EAST PRESTON PARISH COUNCIL

22nd May 2012

Re: EP/40/12 – 115-117 Sea Road, East Preston

Figure 10 - Window Orientation Detail

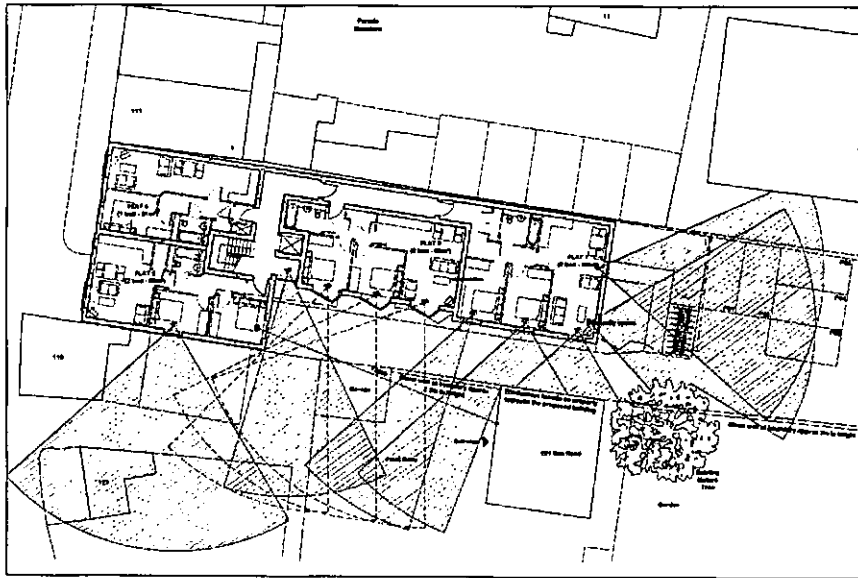
6. The plans with regards to the windows in Flats 2 and 6 are confusing. On the Indicative 3D Visuals drawing, south-east facing windows are clearly shown, but the impact of these windows is not shown on the Window Orientation Detail. These windows will be able to see into a number of windows on the western and northern elevations of 121 Sea Road, and that property's front garden.

drawing: Ground Floor Plan
scale: 1:200 @ A3 date: Dec '11

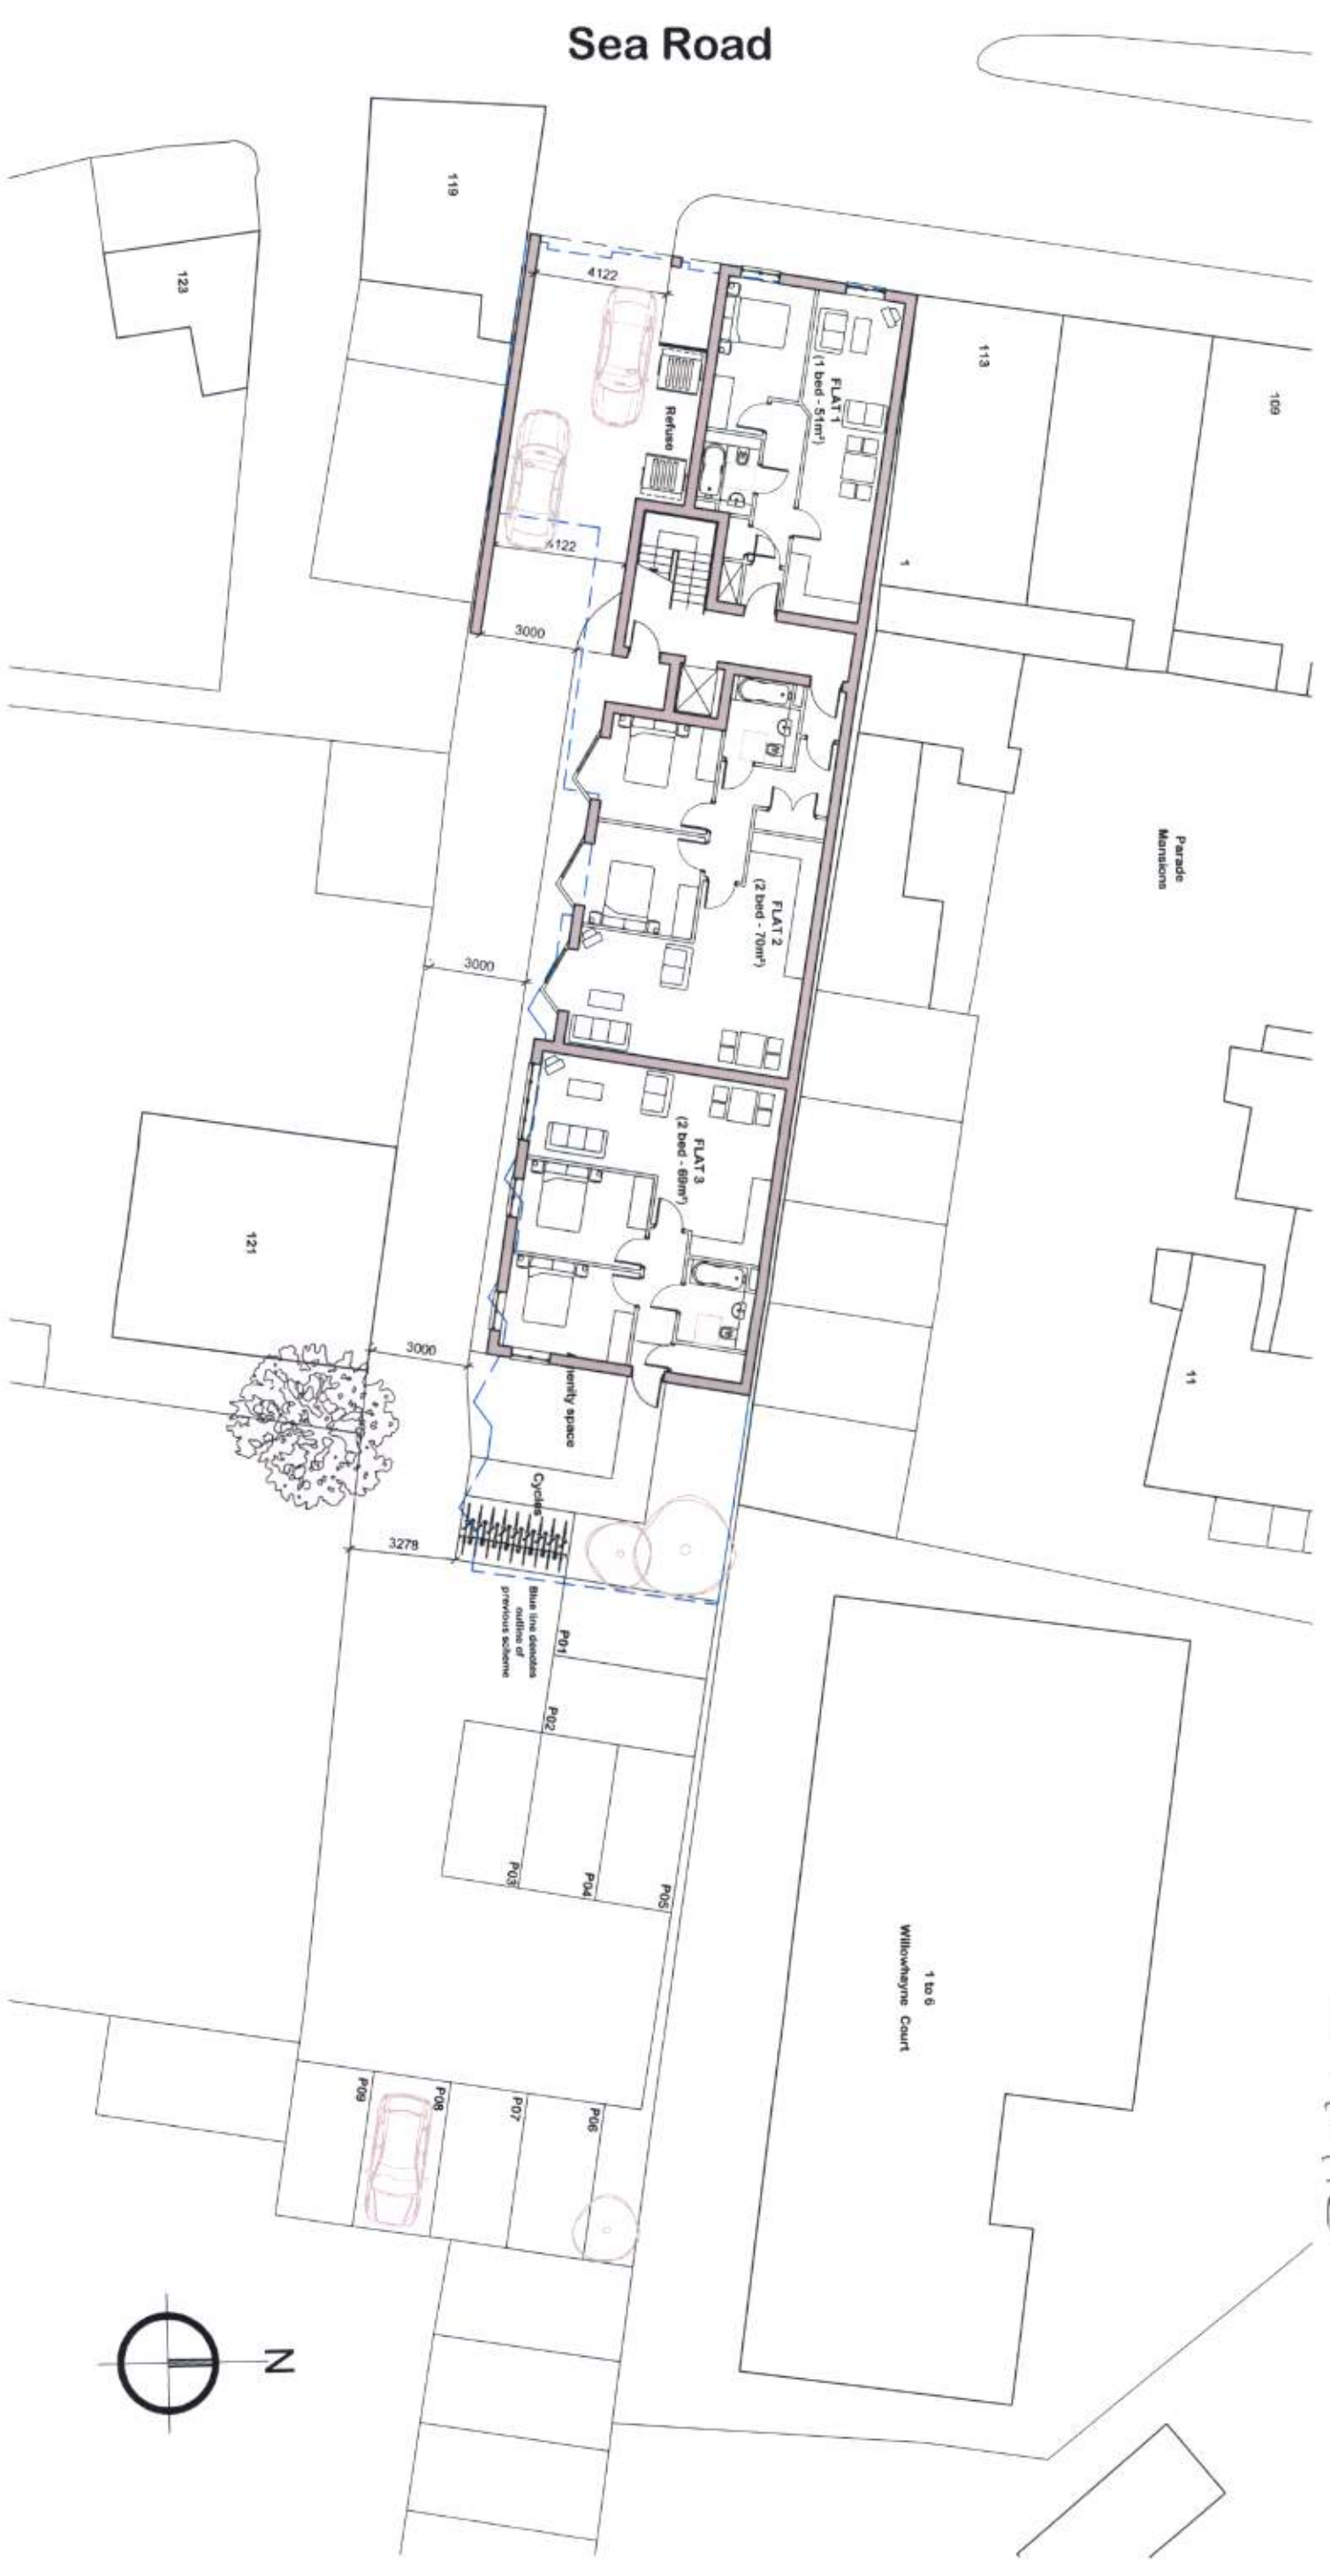
11. This council is concerned also that pedestrian access to the building is through the undercroft with no pavement and no obvious demarcation between pedestrian walkway and vehicle access. Clearly two-way vehicular access/egress is only possible by the omission of a walkway or pavement - there are obvious safety implications here.

although compliant, it would only take one van or lorry to be involved for the narrowness of the vehicle access to lead to instances where vehicles entering from Sea Road may need to reverse back out to let other vehicles out. The danger inherent in reversing out blind in this situation must not be underestimated – if reversing out, visibility splays by necessity will be forgotten about.

project: 115-117 Sea Road, East Preston
client: Oakhurst Developments Ltd
drawing: Roof Plan
scale: 1:200 @ A3 date: Dec '11

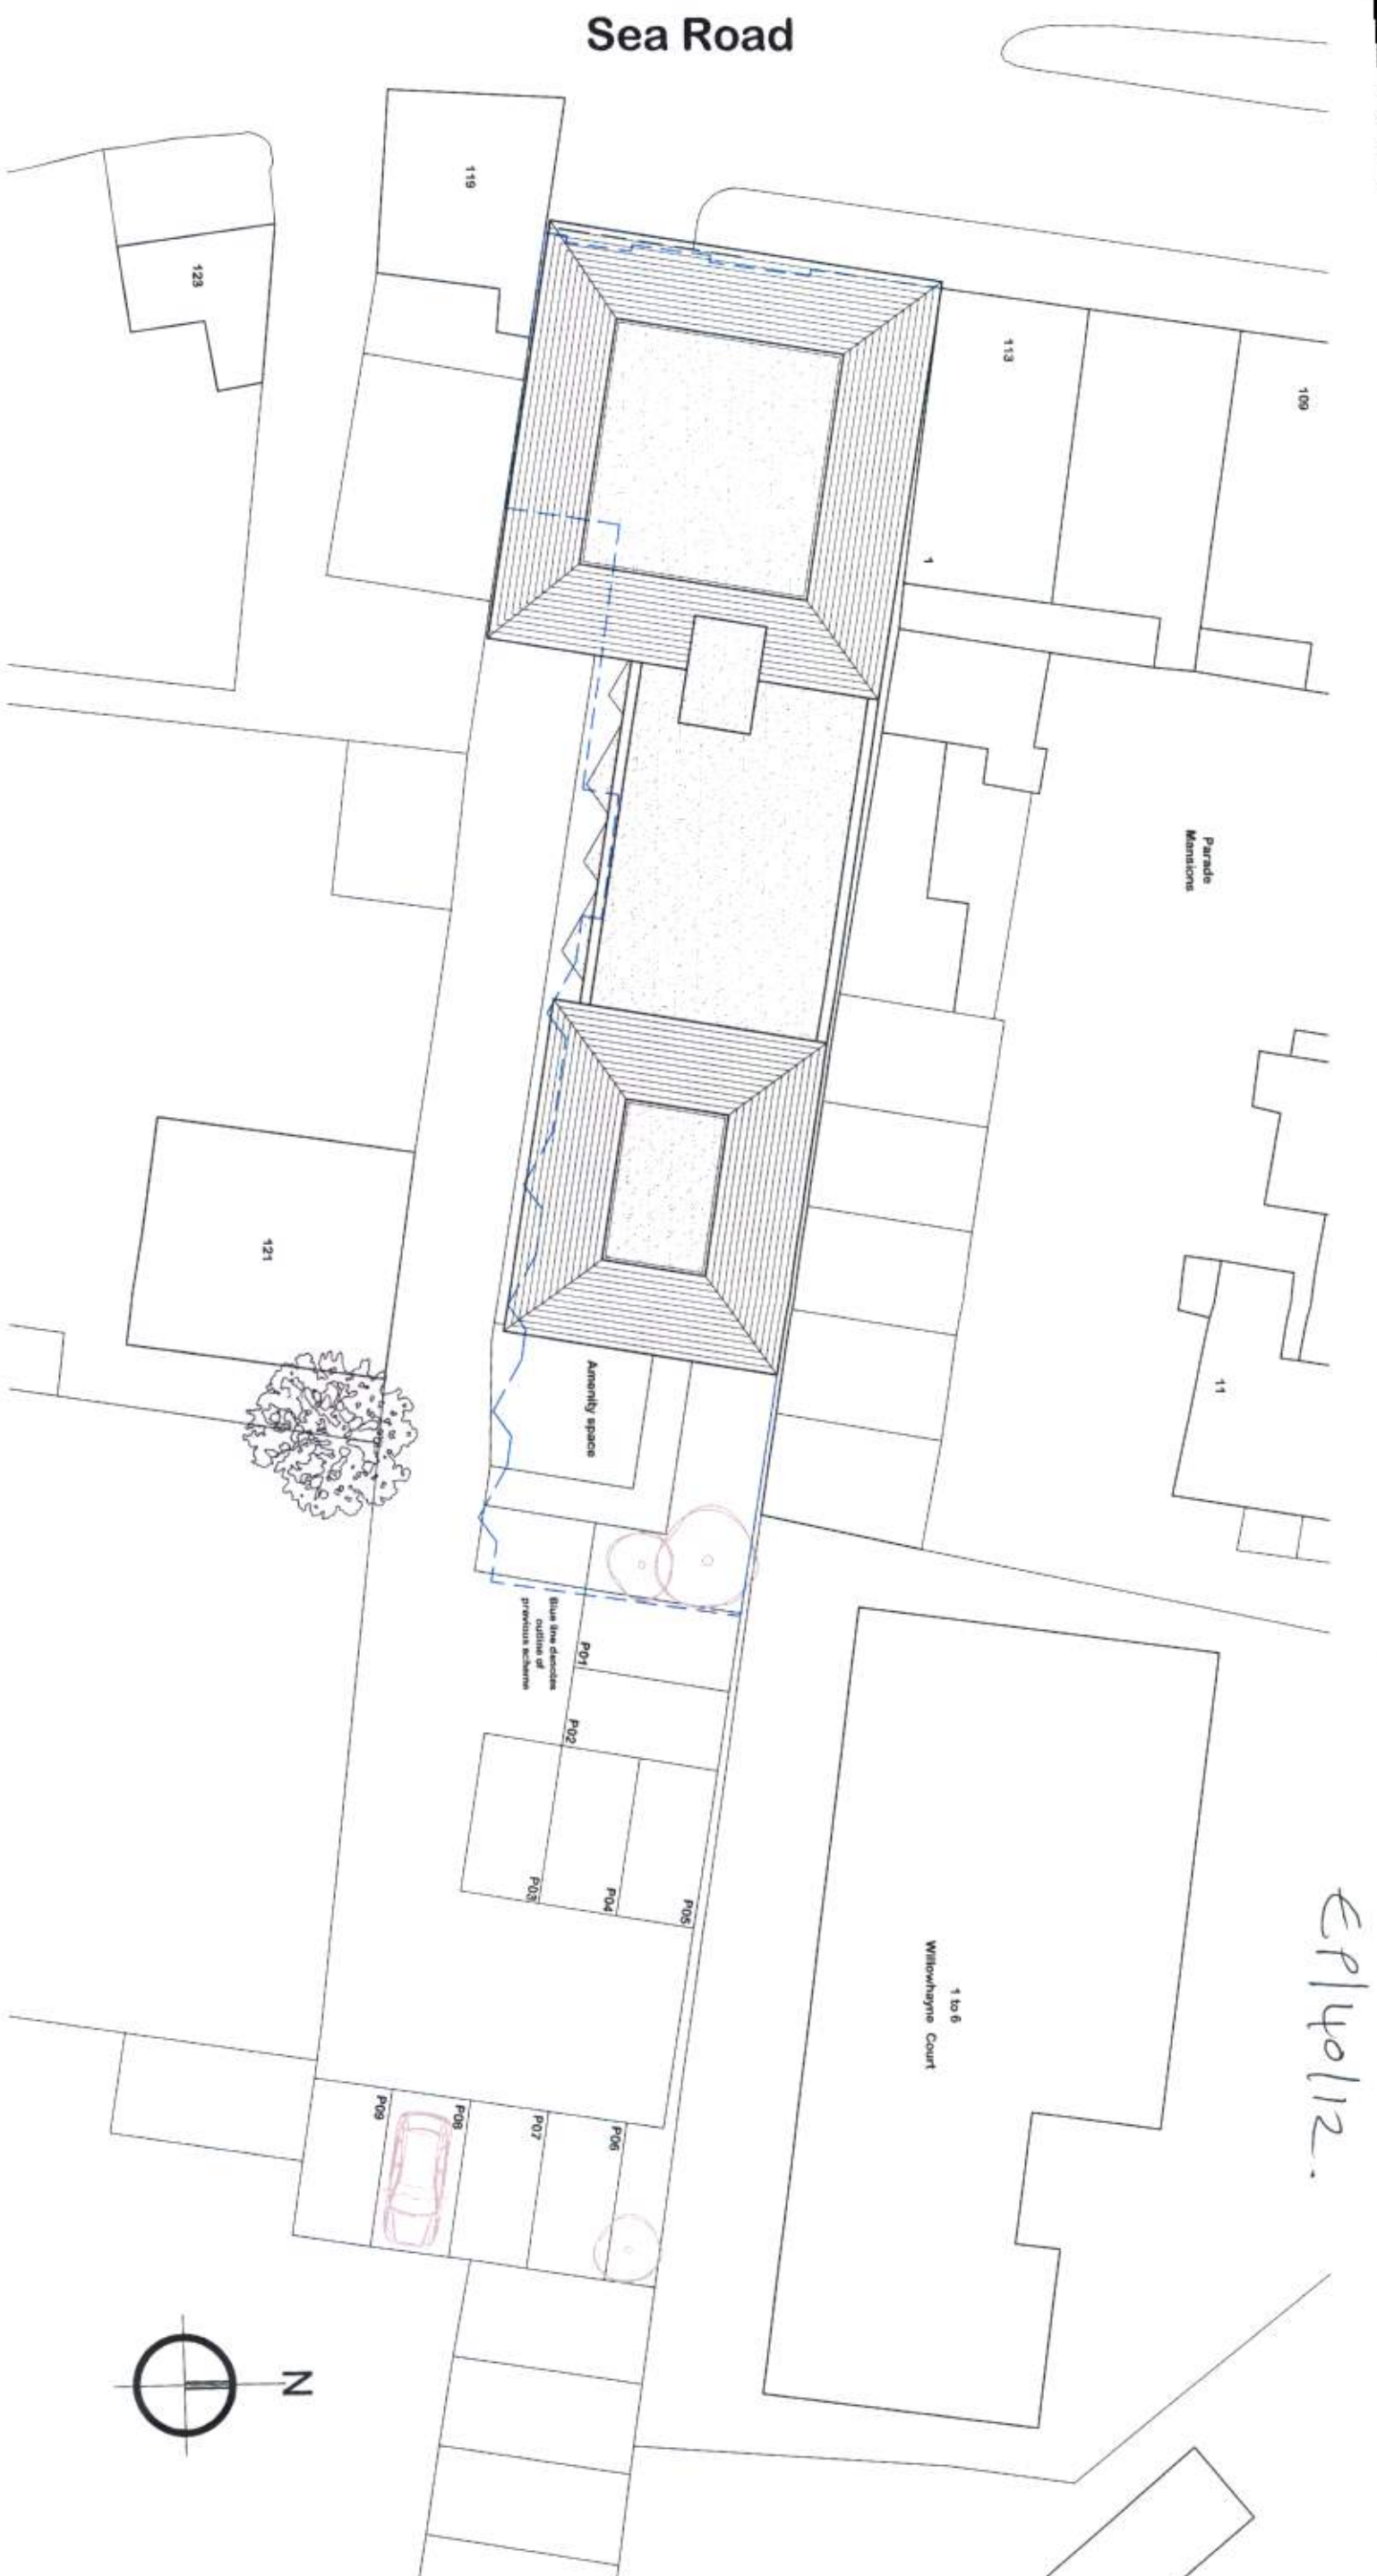
sunlight and its oppressive and overbearing impact. Although not clearly shown on the plans, the roof terrace would also impact upon the enjoyment of neighbouring property owners with the additional concern of noise pollution. The proposal would thereby detract from the amenities and quiet enjoyment of these properties in conflict with Saved Policy GEN7 of the Arun District Local Plan.

drawing: Elevations

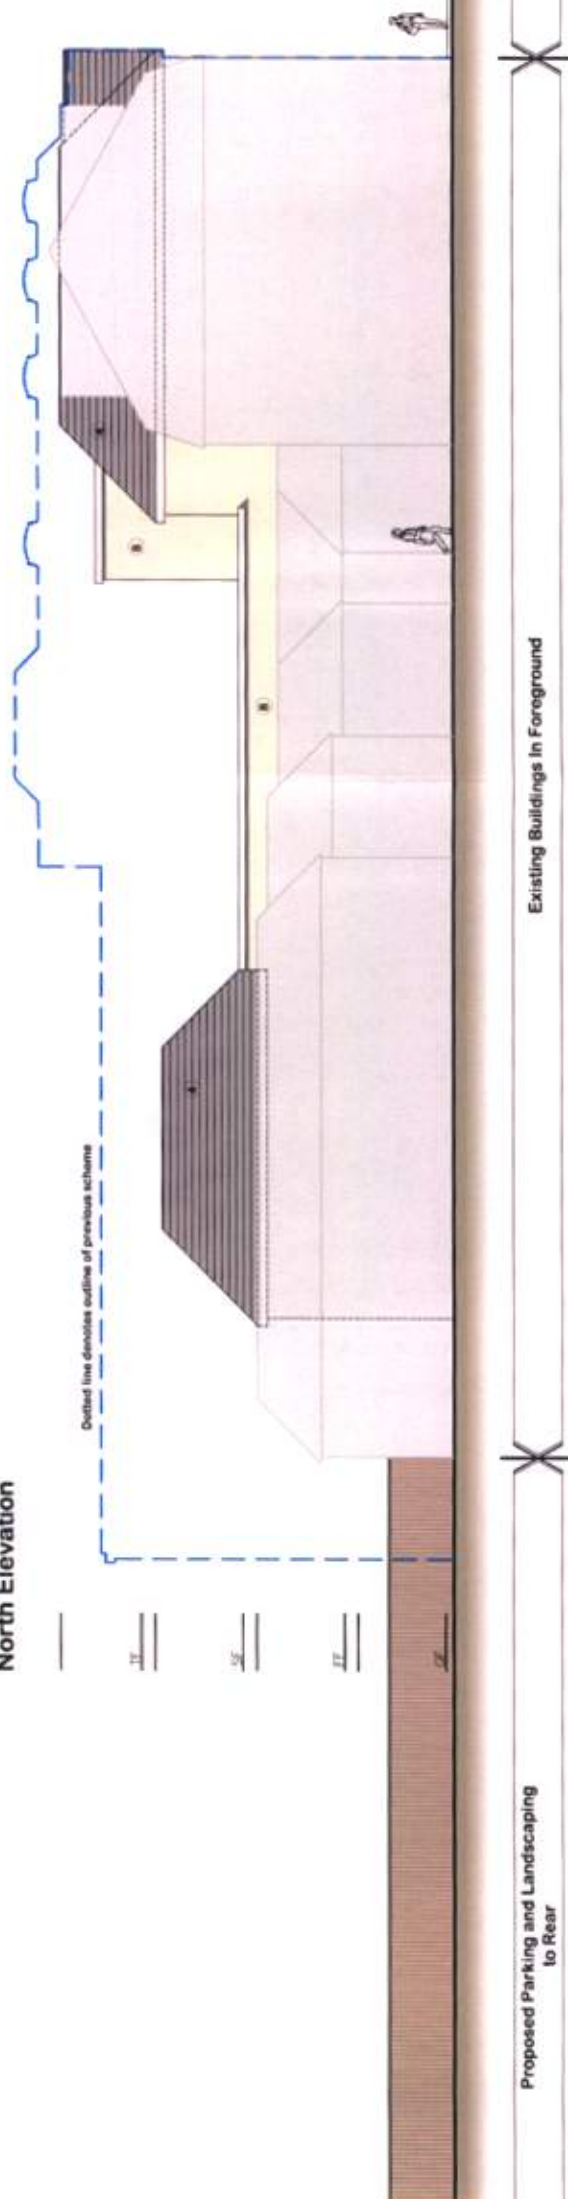
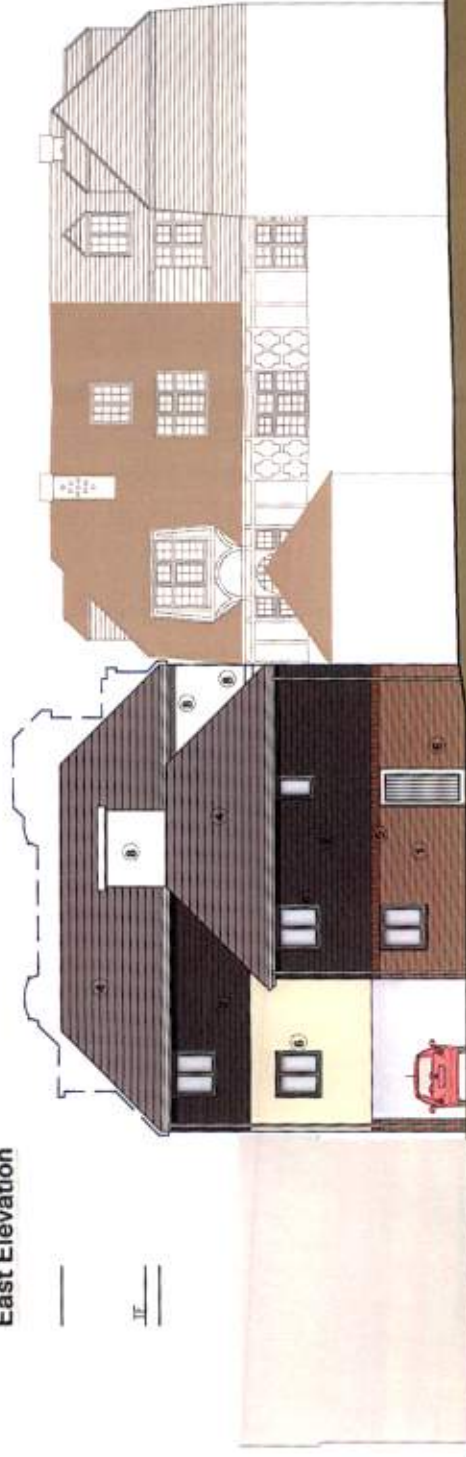
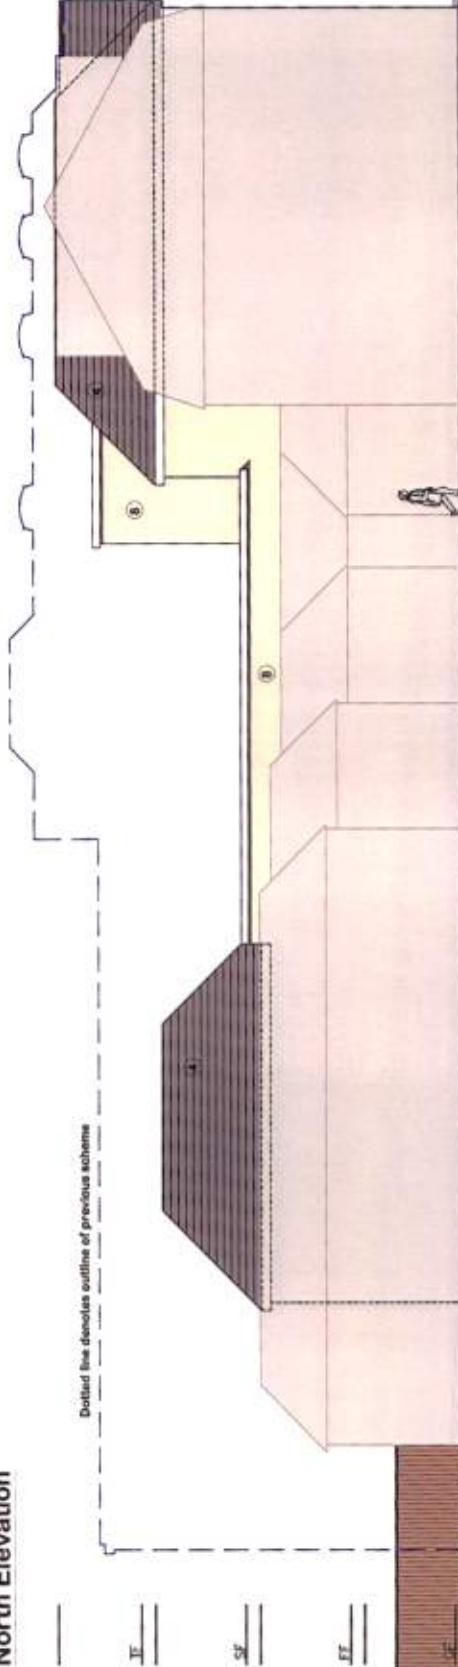
3. The design of the building is inappropriate for its immediate surroundings and does not harmonise with the existing traditional buildings in this parade of shops and the residential accommodation above. Parade Mansions in East Preston's southern shopping area is located in an area of special sensitivity that deserves protection from unsympathetic development. The proposal is therefore contrary to the provisions of the East Preston Village Design Statement (pages 8 and 15 refer). The fact that the existing 115-117 Sea Road are not in keeping must be no reason for the proposed design to be out of keeping too, and the National Planning Policy Framework allows Planning Authorities to refuse Planning Permission to buildings considered to be poorly designed.

8. The proposed contemporary design and materials would have an unacceptable adverse impact on the adjoining existing Parade Mansions buildings which would adversely affect the street scene, contrary to Saved Policy GEN7 of the Local Plan and to the provisions of the East Preston Village Design Statement.
